MMC D Street sidewalk construction

We've been asked to review these plans for MMC, this time for St John St/D St. I will happily compile all of our comments and send back to Nell. So far, here are mine:

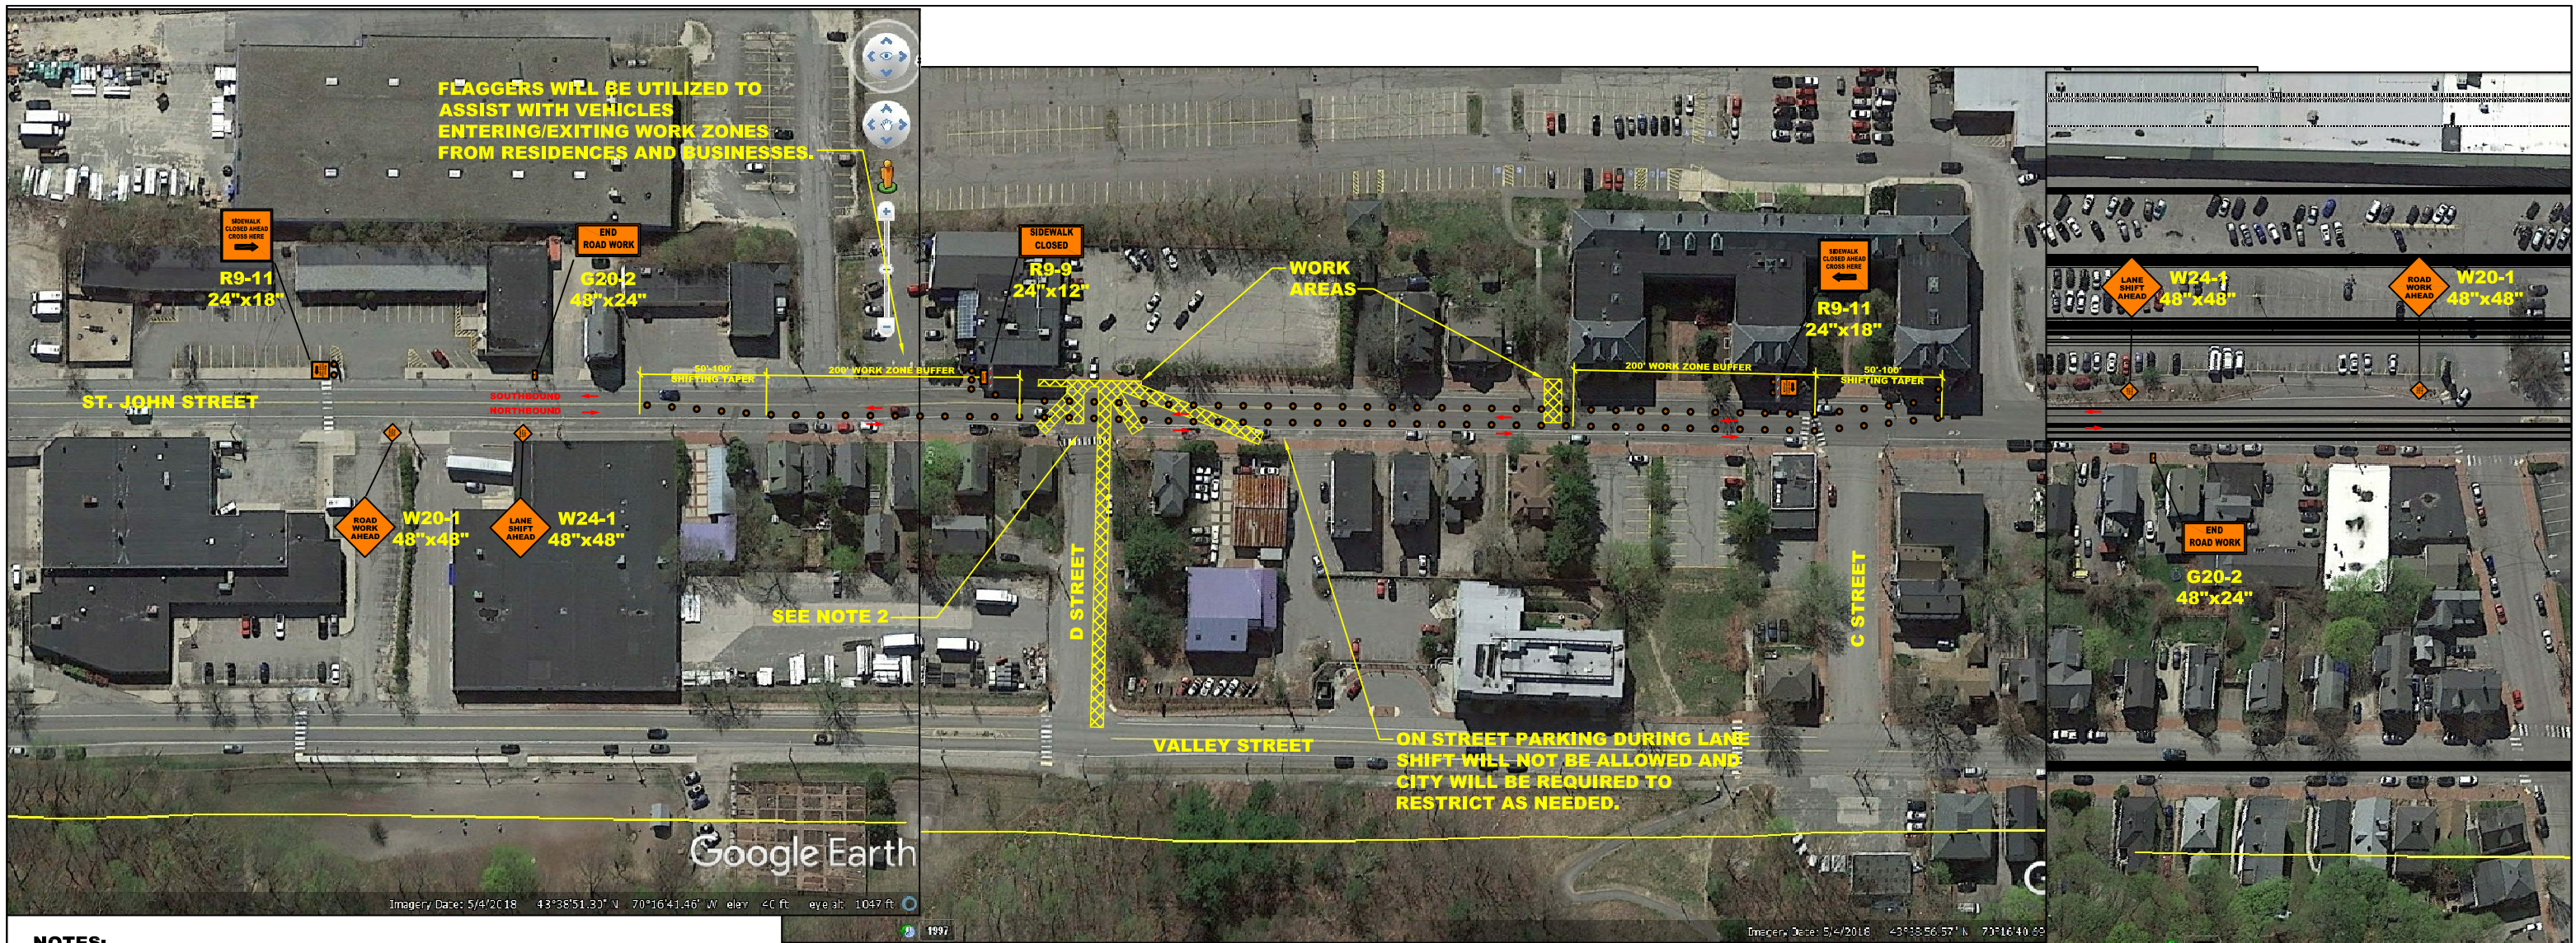
- On-street parking during lane shift is to be coordinated by contractor, not City. Contractor is required to seek out necessary Roadway Occupancy Permits in order to restrict parking, as needed, during the project.

- Confirm crosswalks across D Street will remain open during the duration of work depicted on Sheet 1.

- Confirm that smaller work area on the northern part of the work zone will take the entirety of the phase depicted on Sheet 1. If the work is completed before the work in the St. John Street/D Street intersection, the work zone should be reduced accordingly.

- Shifting tapers should be no less than 75 feet, per MUTCD (10 foot shift, 30mph roadway).

Maine Medical Center Parking Garage		St. John Street - Utilities Work Zone Traffic Control Plan		FIGURE 1		
Shaw Brothers Construction, Inc. 341 Mosher Road, P.O. Box 69 Gorham, Maine 04038 (207) 839-2552		DRAWN:	M.E.		DATE:	3/5/19
		DESIGNED:	-		SCALE:	1"=125'
		CHECKED:	-		FILE:	-
		FILE LOC:	-

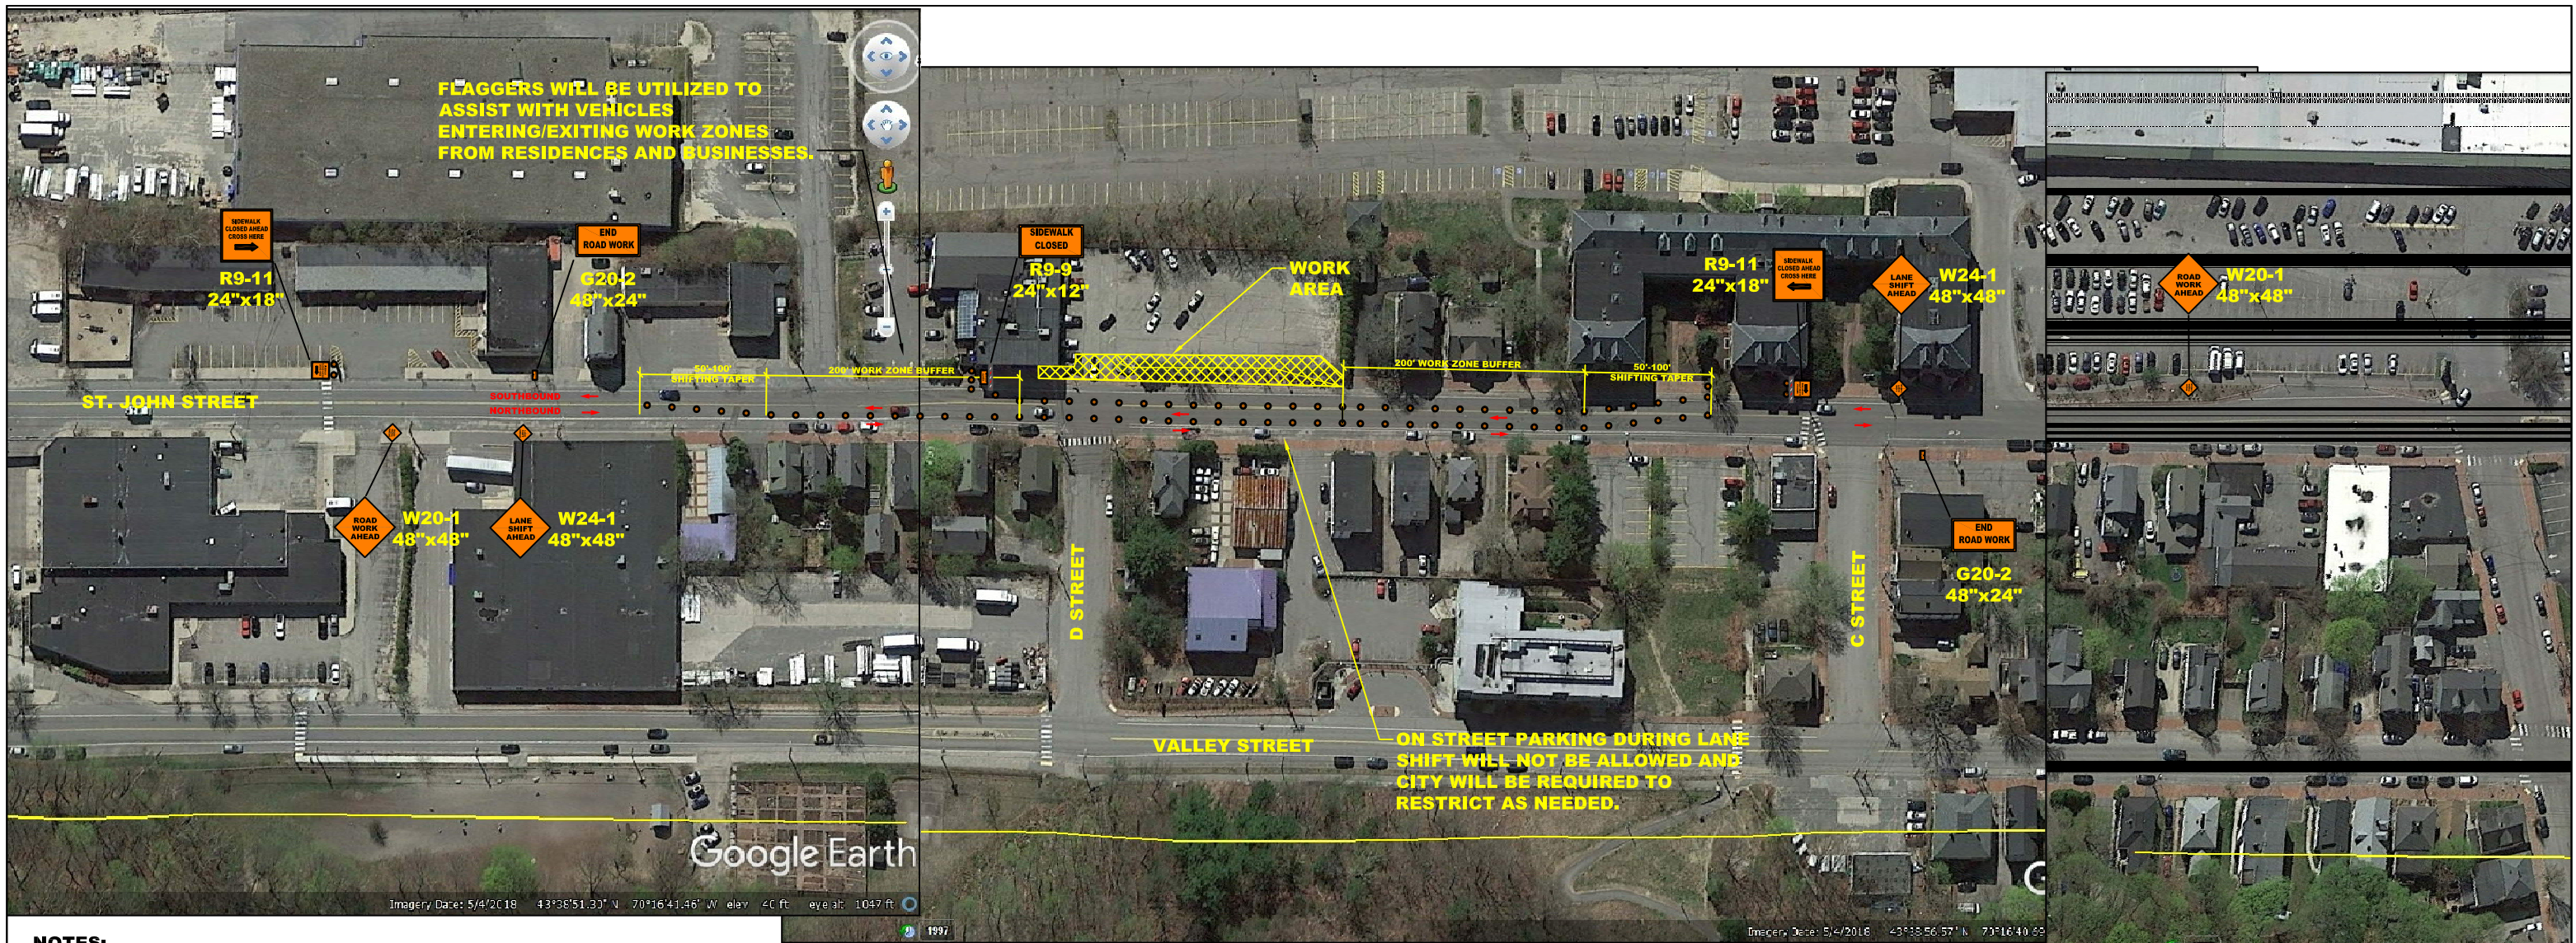
- Same notes as above regarding taper length.
